**Application reference: EN010115**

### **Five Estuaries Offshore Wind Farm Project**

## Appendix 1: Response to section 51 advice / section 55 observations

[Continues on Sheet No. 4]  
 [Continues on Sheet No. 5]

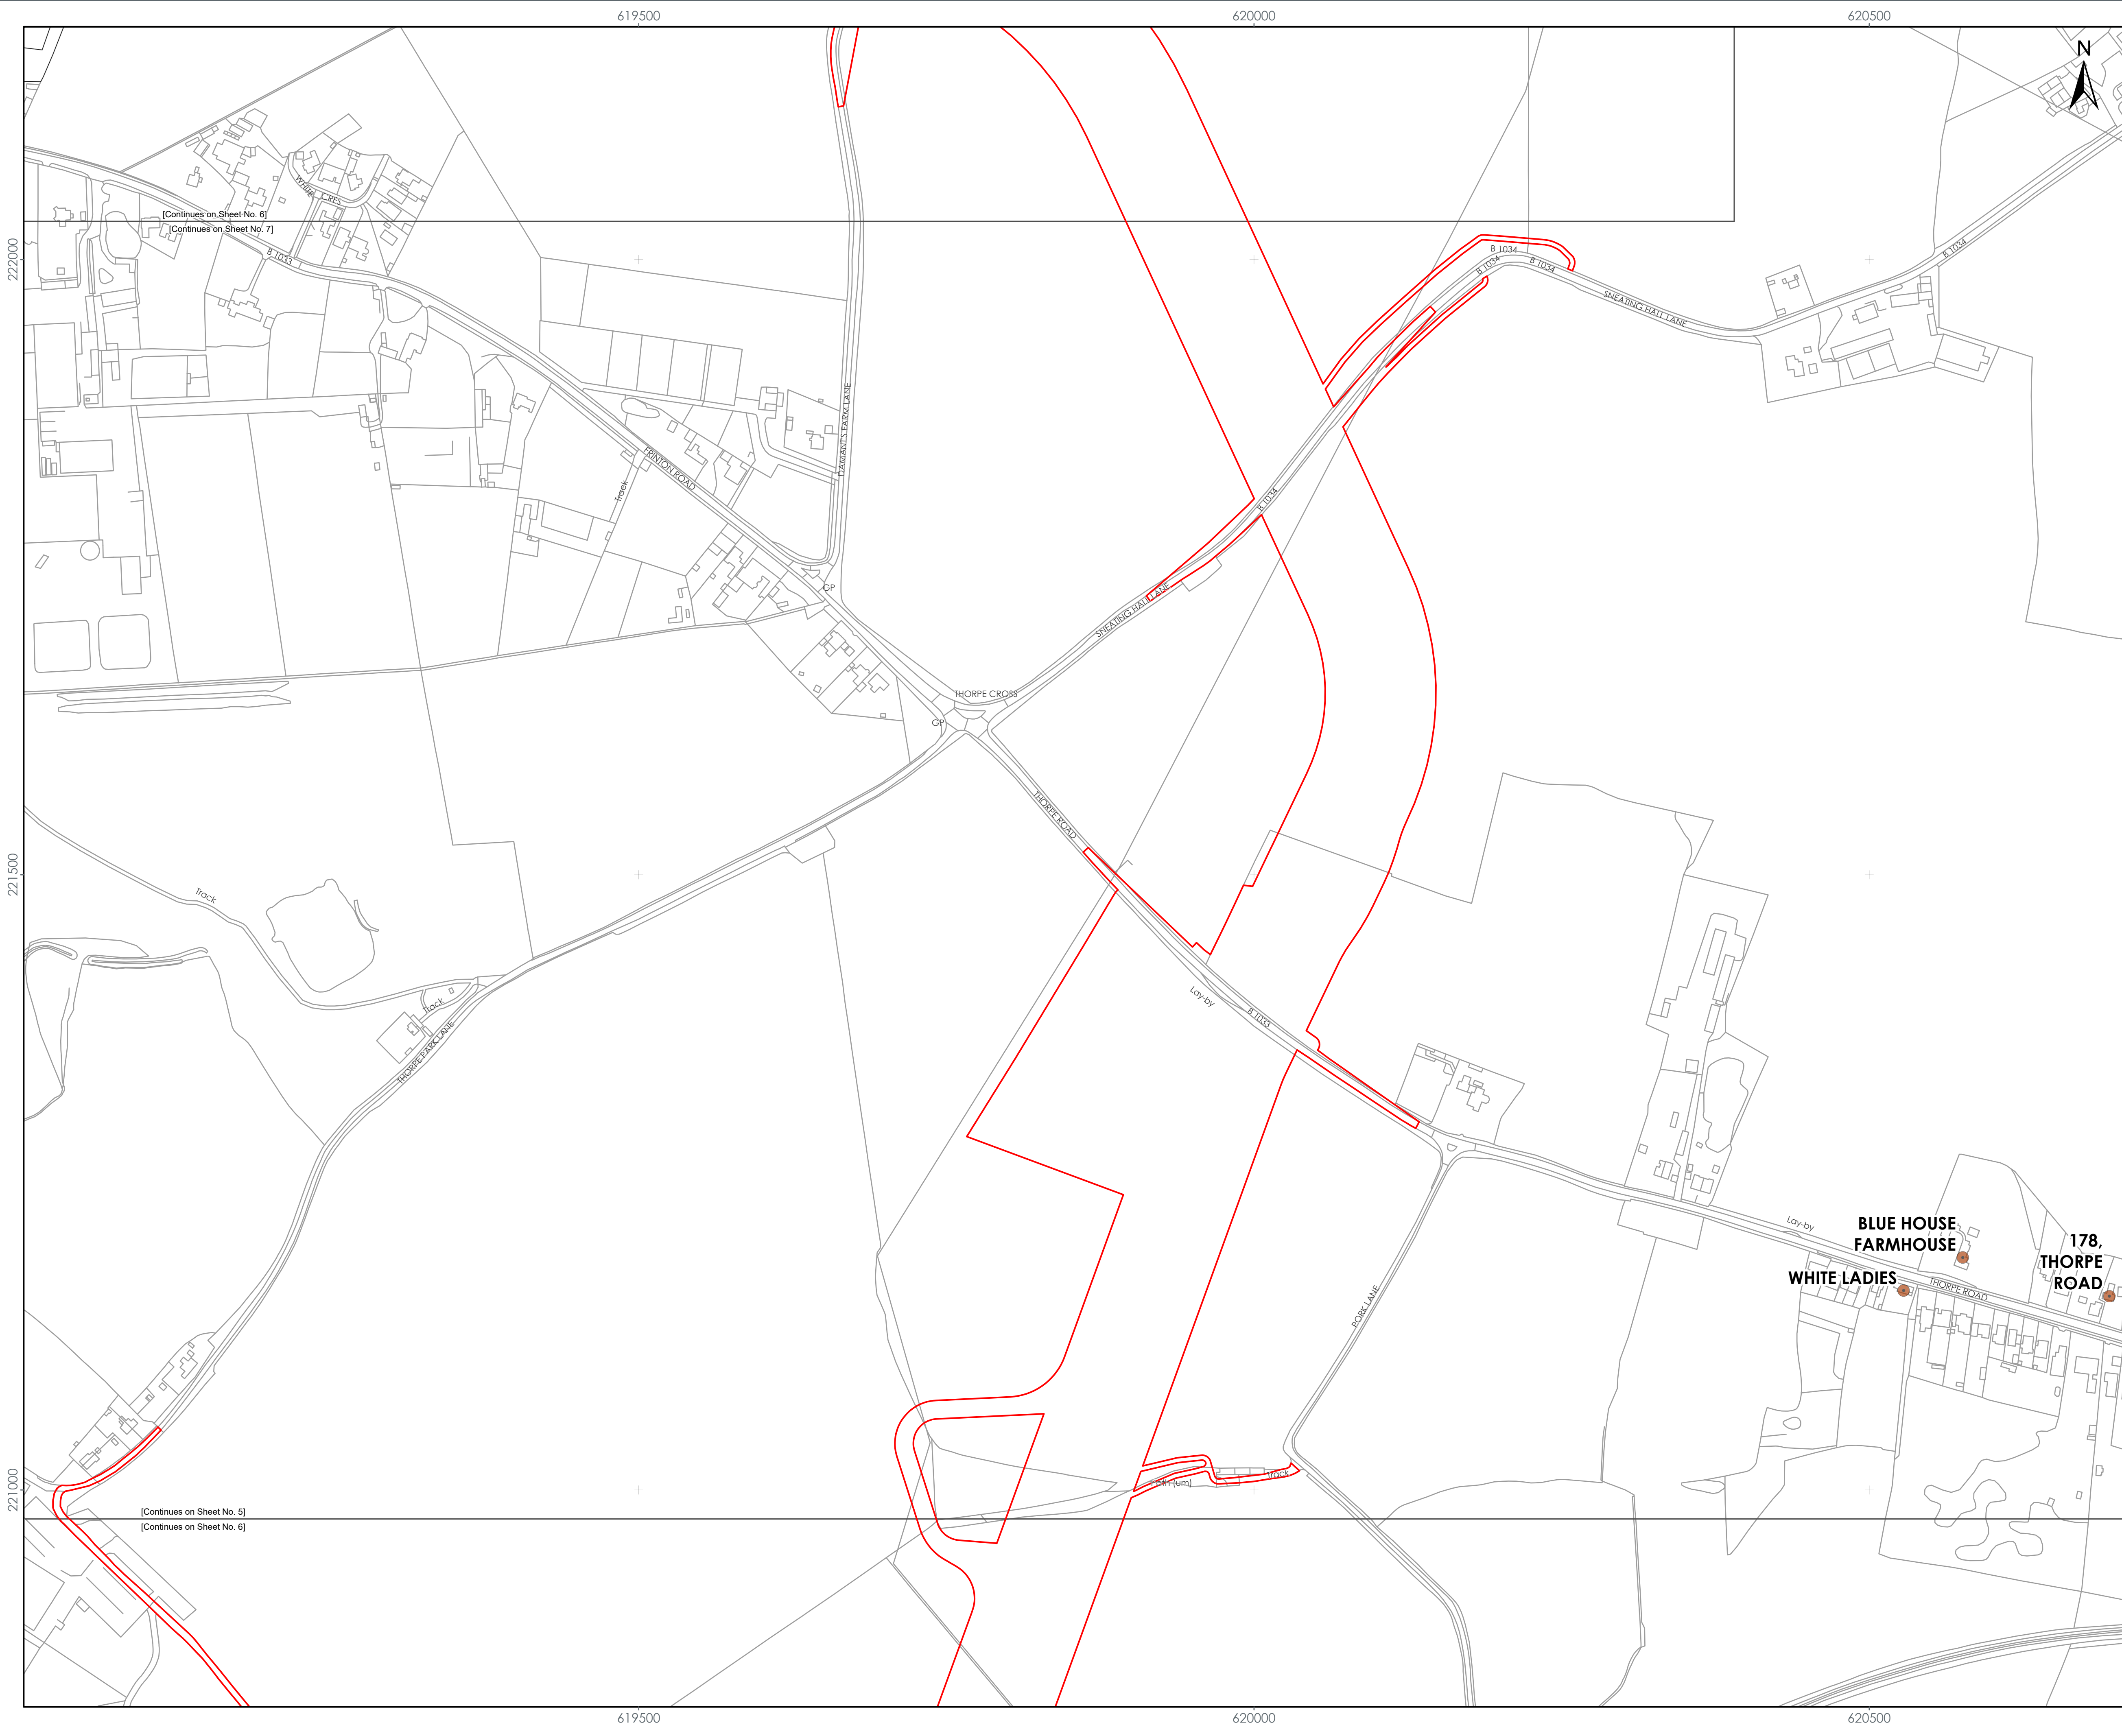
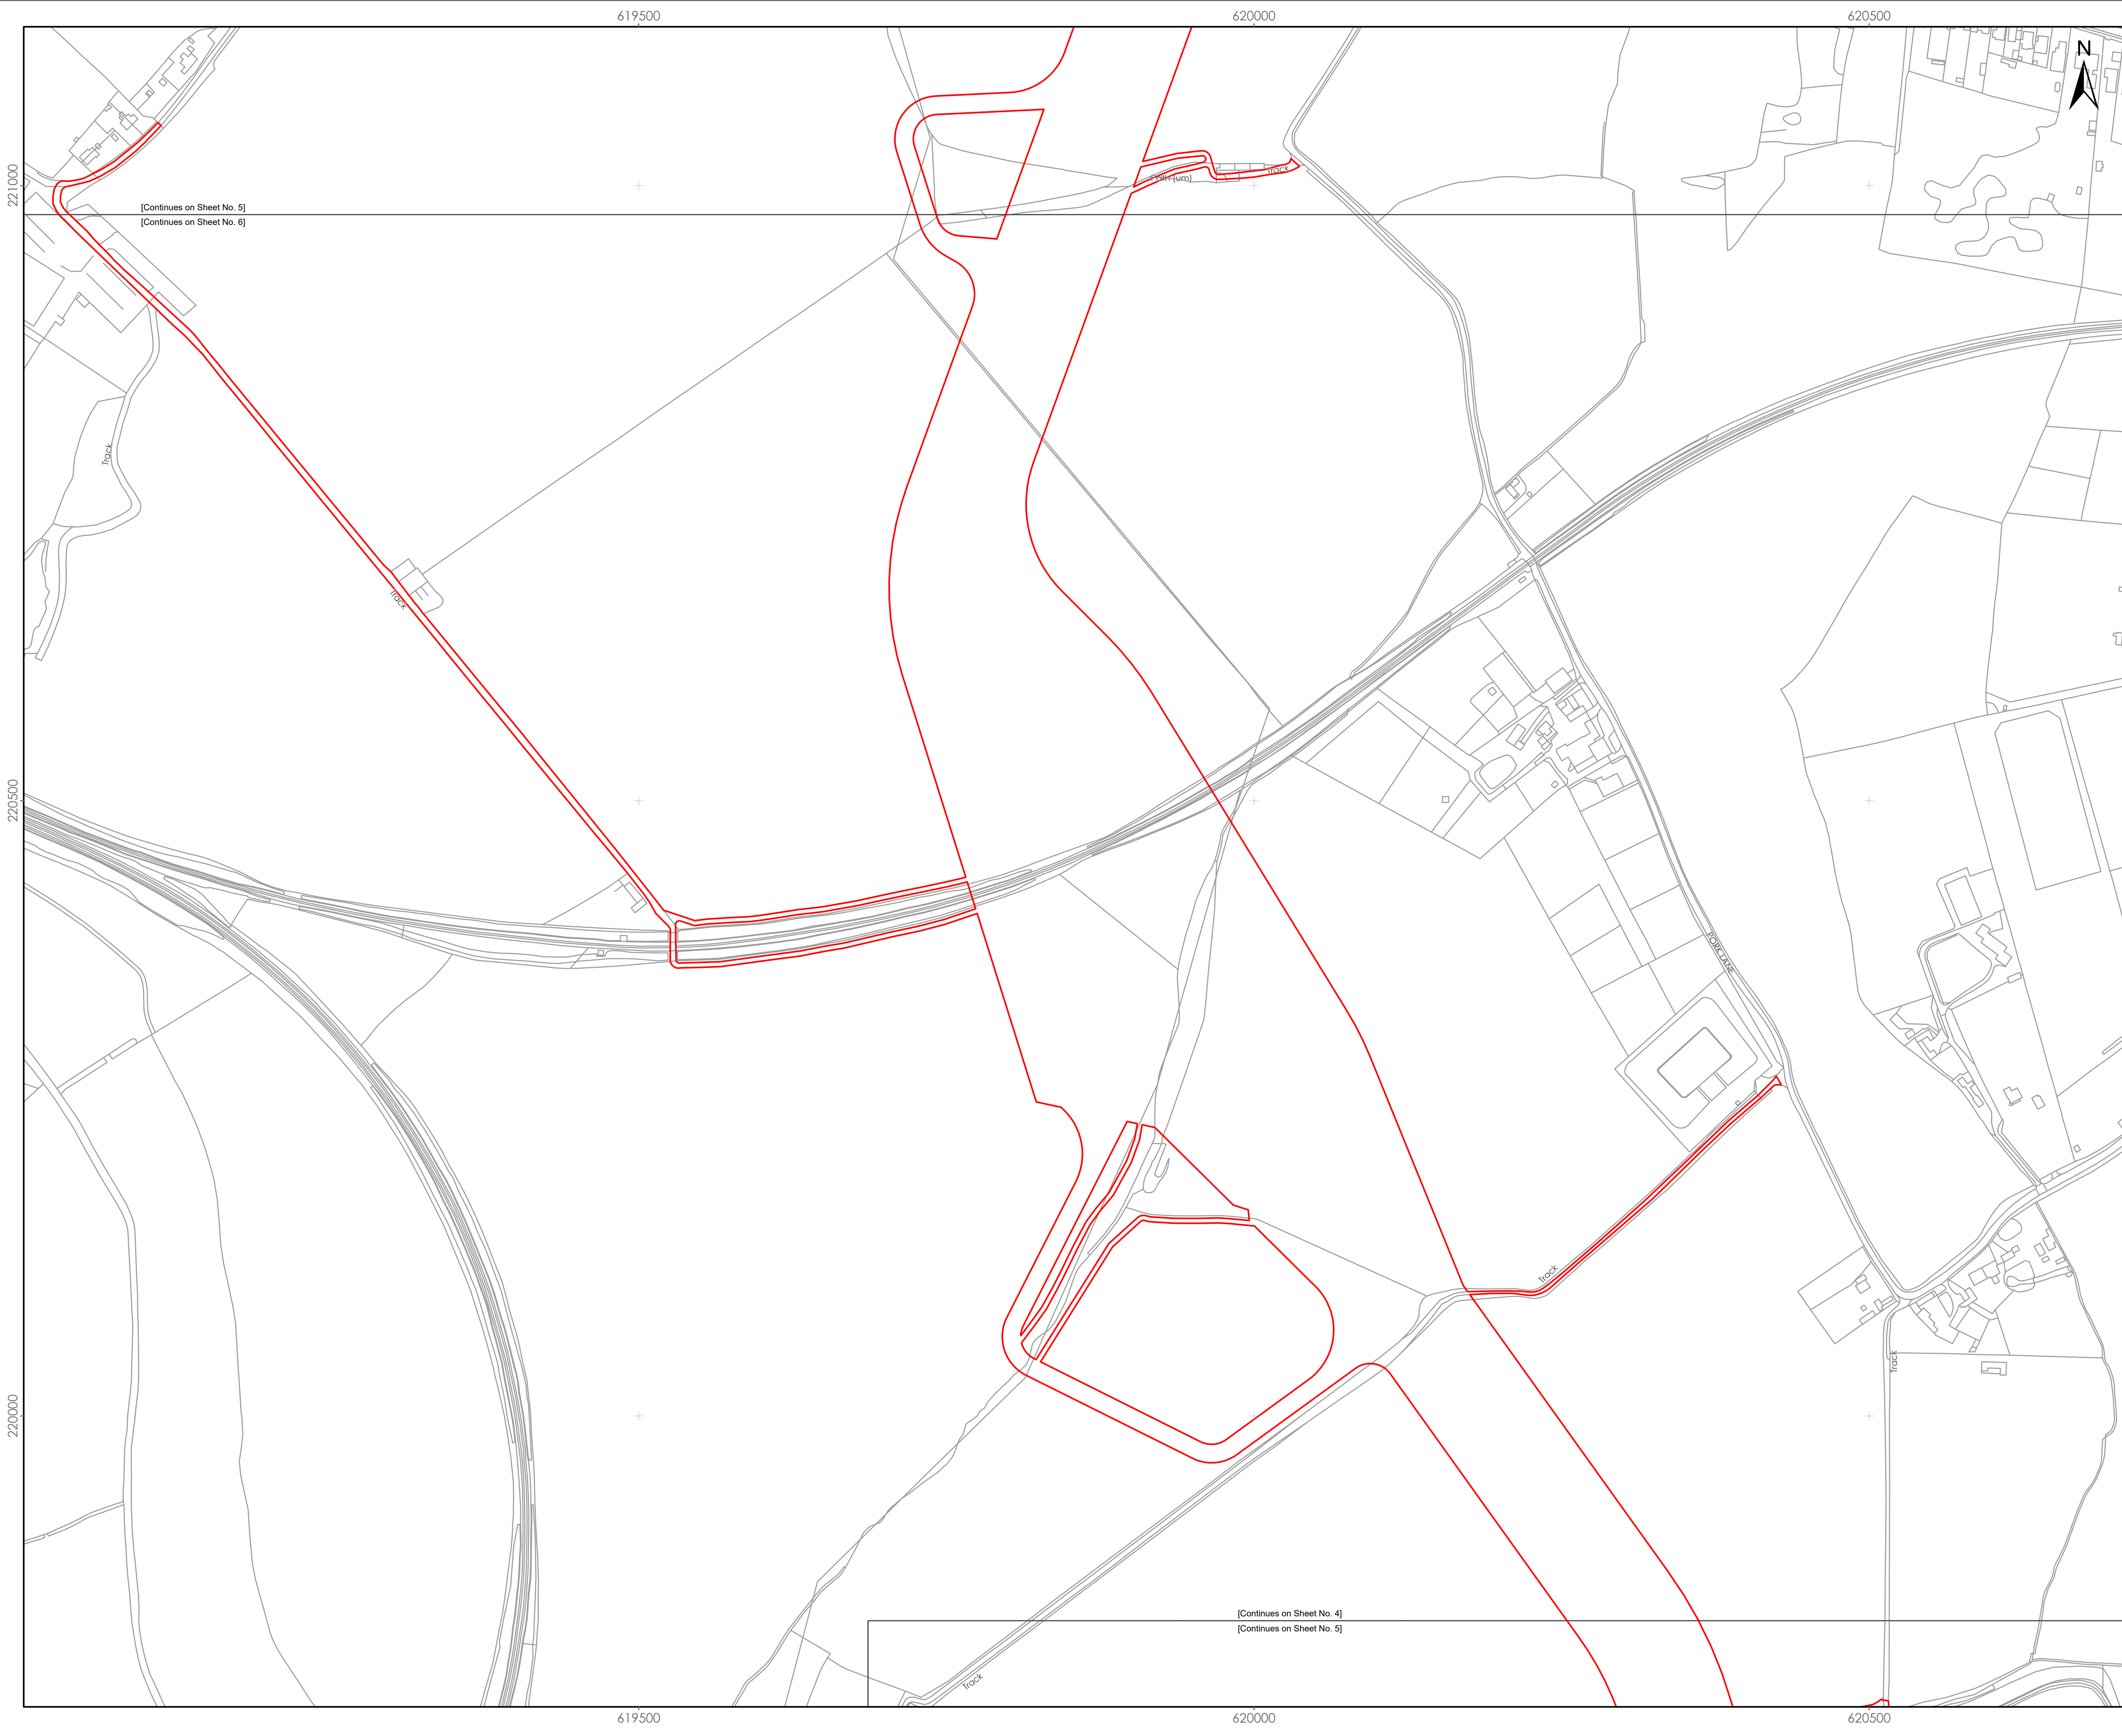
Sheets 1 to 7's are difficult to read due to the resolution being low.	all consistent, rather than having different base mapping.
Historic Environment Plan – Onshore (document reference 2.11)	Historic environment plans show a woodland layer on the key, but this is not visible on the plans. These plans also show ancient woodland which may not be required in the historic environment context and could be included in the Statutory or Non-Statutory Sites and Features of Nature Conservation - Onshore plans (Doc 2.13).	No changes are proposed at this stage as the woodland layer is not key to understanding the plans or a statutory feature.  The project notes that ancient woodland is already included on Statutory or Non-Statutory Sites and Features of Nature Conservation - Onshore plans (document reference 2.13).
Crown Land Plan – Onshore (document reference 2.17)	The colour used for Crown Land in the Legend of Sheet 2 of 2 does not seem to match the colour used on the plan.	No changes are proposed. The land parcel 20-002 shown on Sheet 2 of 2 of the Crown Land Plan – Onshore (document reference 2.17) has land interests from both parties in the key. It is therefore correct as shown.
